SOUTH HOLLAND DISTRICT COUNCIL

Purpose: To consider Planning Application H22-0801-24

Description: Residential Development - Erection of 2 Dwellings - Outline Approval H22-1070-23

Location: Off High Road Weston Spalding

Street Scene Sectional Elevation 'A-A' to High Road

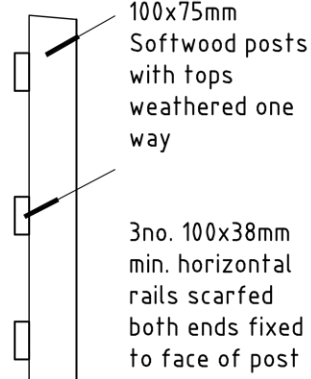
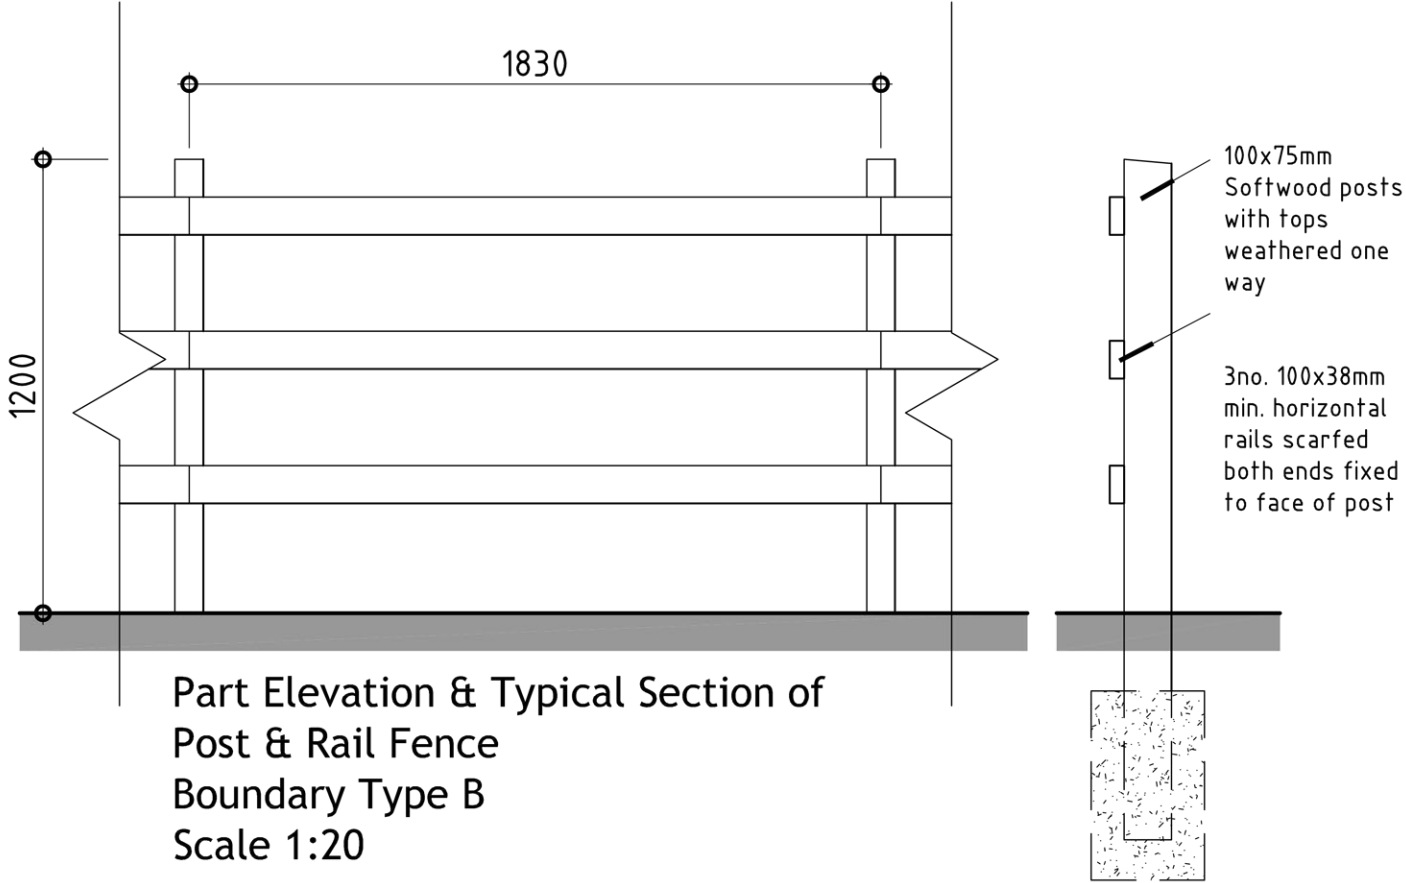
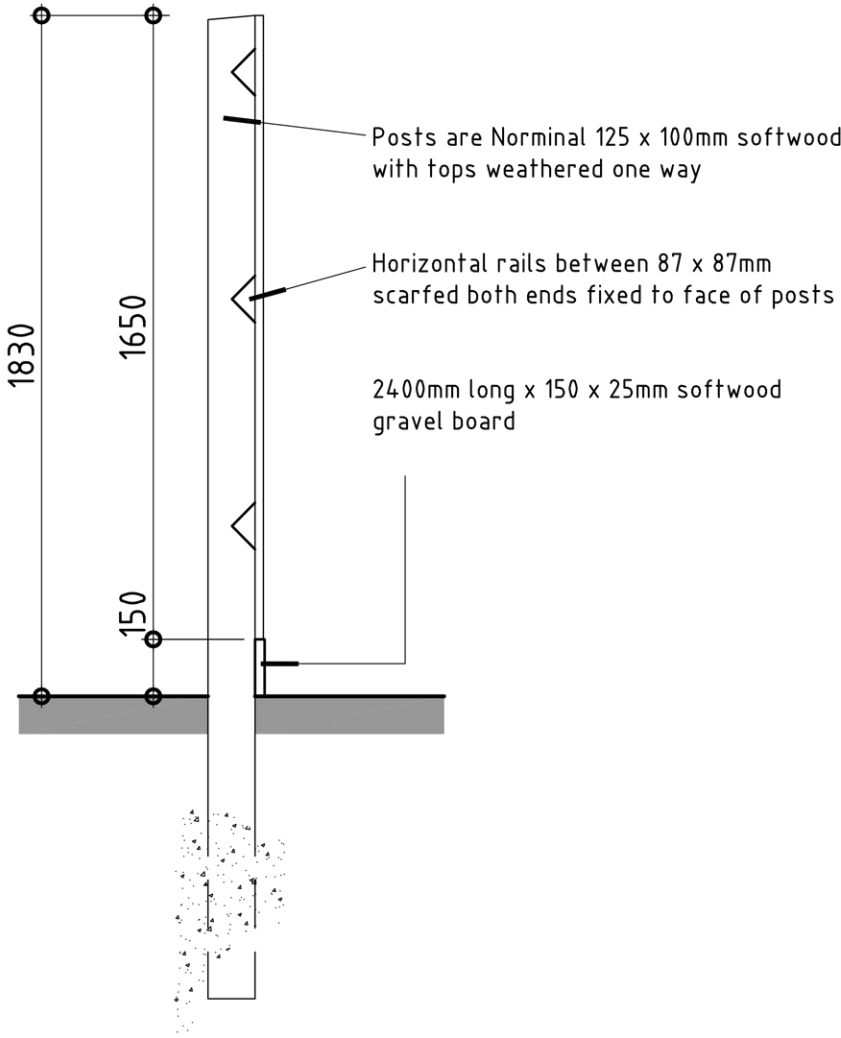
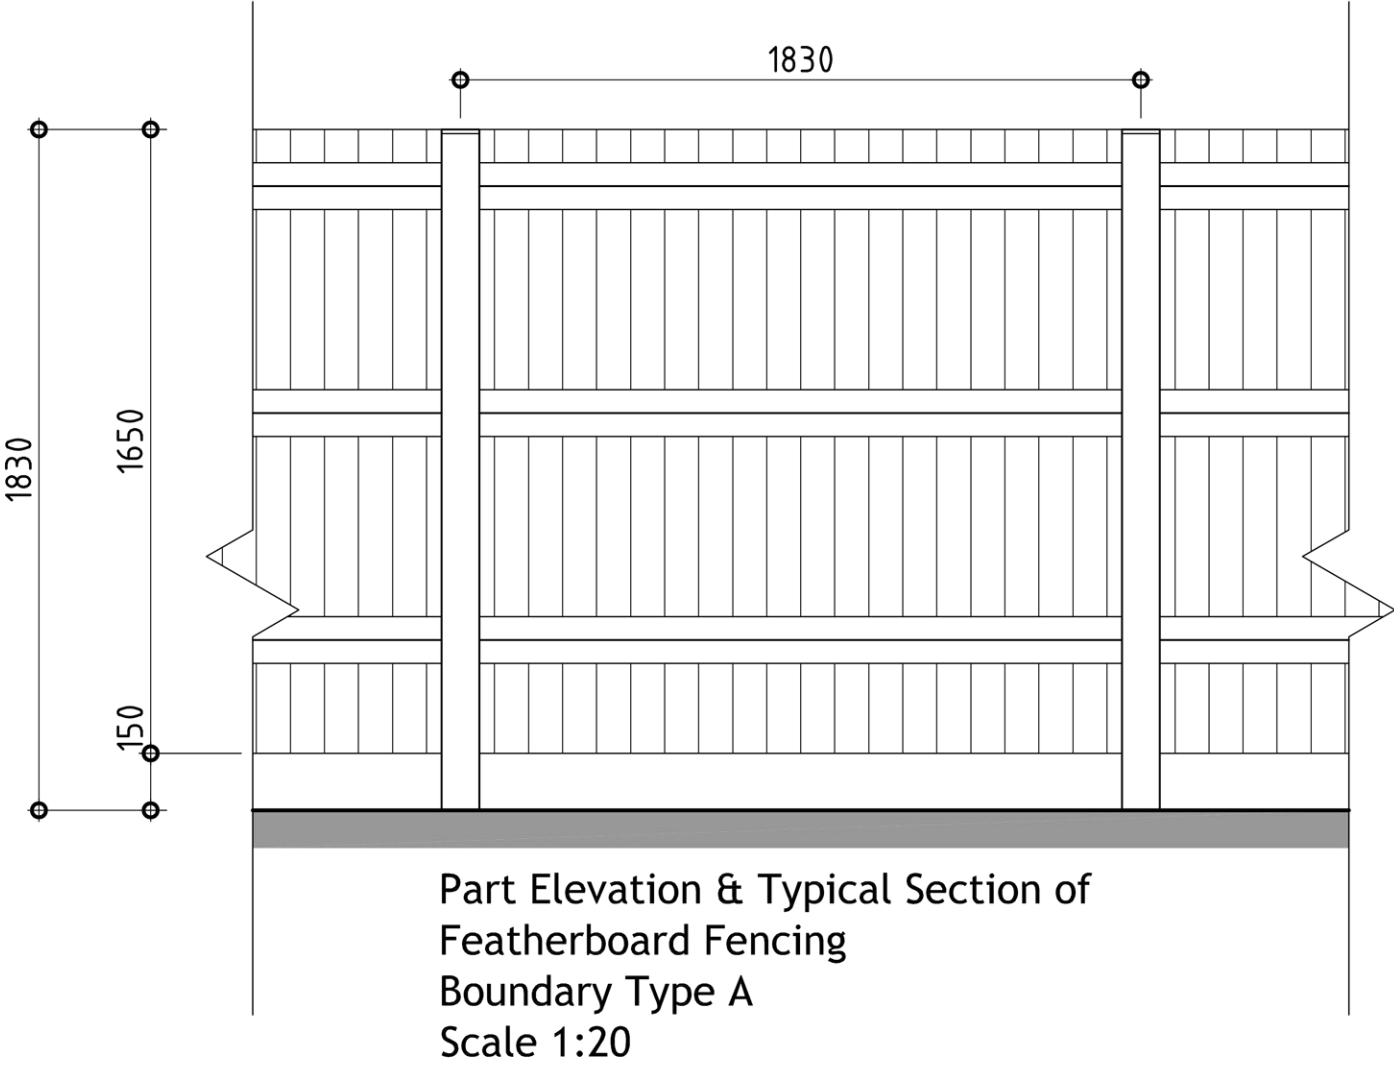
- 7.25 The proposed finished floor levels for both properties are 3.725m which is 0.765m above existing ground level for Plot one and 0.715m above existing ground level for Plot two. The finished floor levels of the proposed dwellings are notably raised in relation to the proposed land level; however, this would comprise such an extent that would not materially impact the street scene or neighbouring residents. Notwithstanding this, the conditions attached to the Outline Approval specifically seek the submission of site levels and finished floor levels; therefore, details must be provided through the submission of a discharge of conditions application at a later date.

- 7.26 A street view plan has been submitted to show the extent of the impact to the neighbouring dwellings and the visual impact upon the surrounding context, and it is considered that the proposed levels raise and adequate separation distances ensures no unacceptable impact.
